An  
Coimisiún  
Pleanála

**Record of Meeting**  
**ACP-323831-25**  
**1<sup>st</sup> meeting**

<b>Case Reference / Description</b>	ACP-323831-25 – West Clare Railway Greenway Project - Section 1 (Kilrush to Kilkee). Kilrush to Kilkee via Moyasta, Co. Clare		
<b>Case Type</b>	Pre-application consultation		
<b>1st / 2nd / 3<sup>rd</sup> Meeting</b>	1st Meeting		
<b>Date</b>	05/03/2026	<b>Start Time</b>	11:00 a.m.
<b>Location</b>	MS Teams	<b>End Time</b>	12: 00 p.m.

Figure 4-3 View west from the L6048 where the proposed development will pass by the old railway cottage

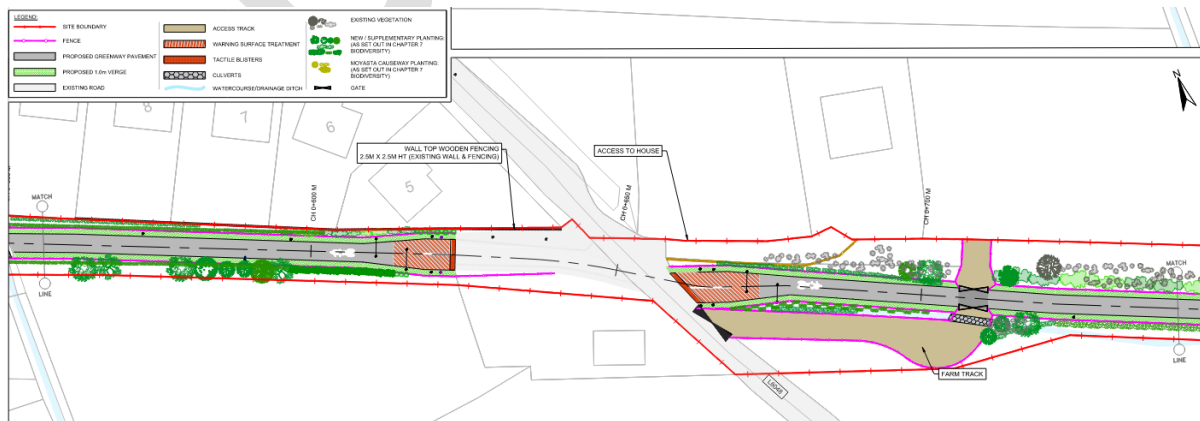
The Commission representative also queried whether the entire route has surveyed noting that some sections appear overgrown particularly after the railway cottage approximately 1.3 kilometers along the route from Kilkee.

In response, the prospective applicant stated that each discipline contributing to the EIAR has been responsible for its own surveys and that no concerns have been identified. It was confirmed that all survey work will be documented in the EIAR.

Figure 4-6 Excerpt from Figure WCGW-ROD-HGN-S1_ML-DR-CH-200504 from Volume 3 illustrating how the proposed development will divert around an existing dwelling and cross the L2018.

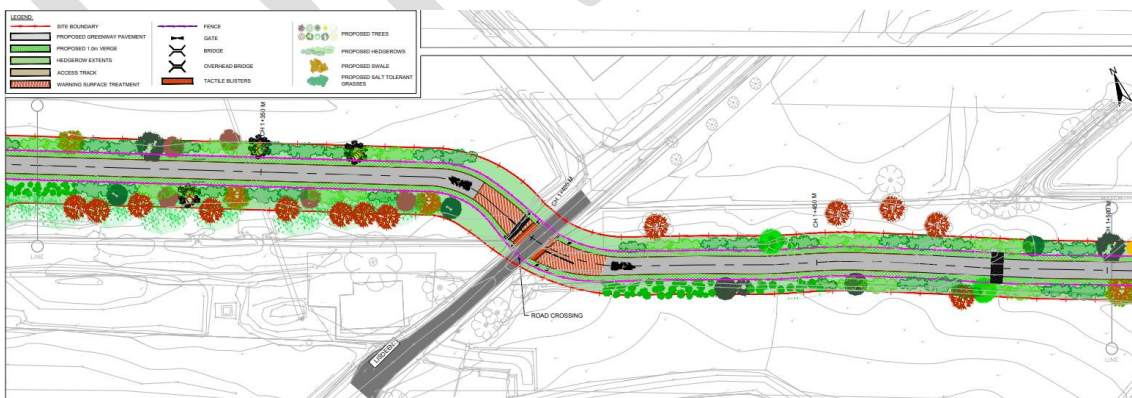
The Commission's representative further queried with reference to Figure 4.4. 'landowner accommodation works will be provided, as required" and whether these matters would be agreed, post decision.

In response the prospective applicant noted that conditions will vary from point to point. There are, however, certain areas where agricultural vehicles will be able to access the crossings.

Figure 4-8 Proposed locations of bridges in red arrows and landowner bridge in yellow arrows near Lisdeen Recycling Centre

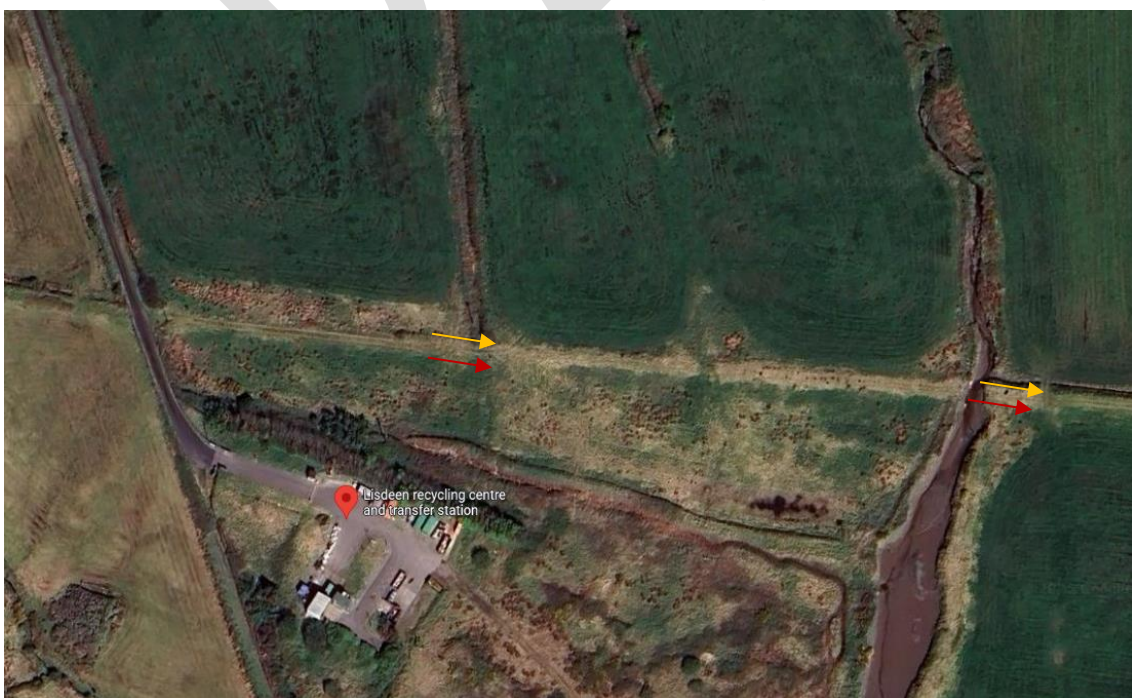
The Commission's representative queried the status of the 32 proposed structures, including the 8 clear span bridges. They asked whether each bridge will be individually designed or follow a standard design and whether full drawings, sections and elevation details will be provided. The Commission's representative also noted piles are proposed near the recycling center and asked about ground conditions.

The prospective applicant confirmed that drawings exist for new bridges, including foundations and flood compatible infrastructure details.

Figure 4-17 Proposed alignment along the N67 at Moyasta

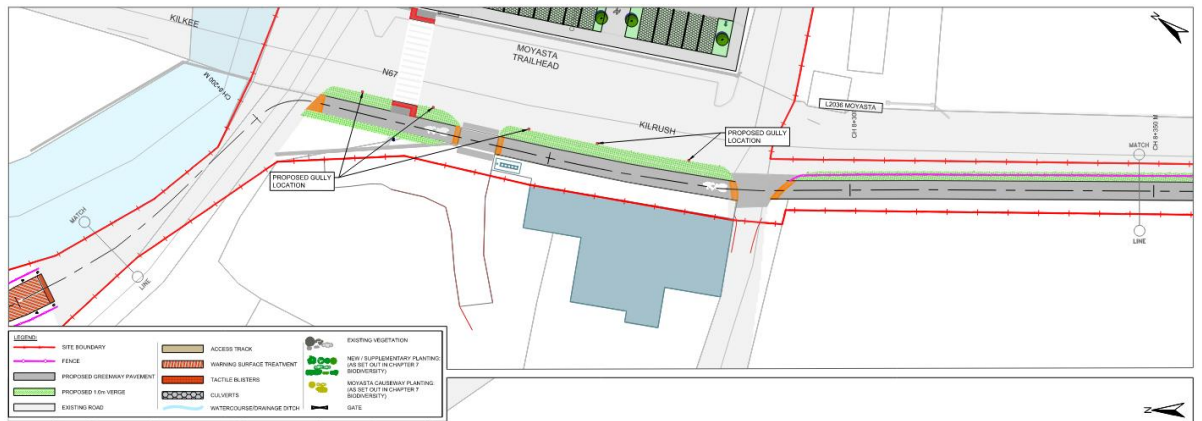
The Commission's representative queried the statutory consultees noting reference to the Parks and Wildlife Service and Birdwatch Ireland. The Commission's representative asked whether Transport Infrastructure Ireland (TII) has been consulted in regarding the zebra crossing that is proposed at Moyasta and noted that Chapter 4 (page 19) of the EIAR states that utility companies will be consulted as part of the detailed design. The Commission representative asked whether any contact or consultation has taken place with the utility companies to date, noting it is unlikely that there are any significant utilities along the rail line.

In response, the prospective applicant stated that the EIA Scoping Report has been sent to all the statutory consultees and responses have been received. TII, as the sponsors of the scheme, are closely involved and aware of the proposed zebra crossing. The prospective applicant further noted that there are no major utility
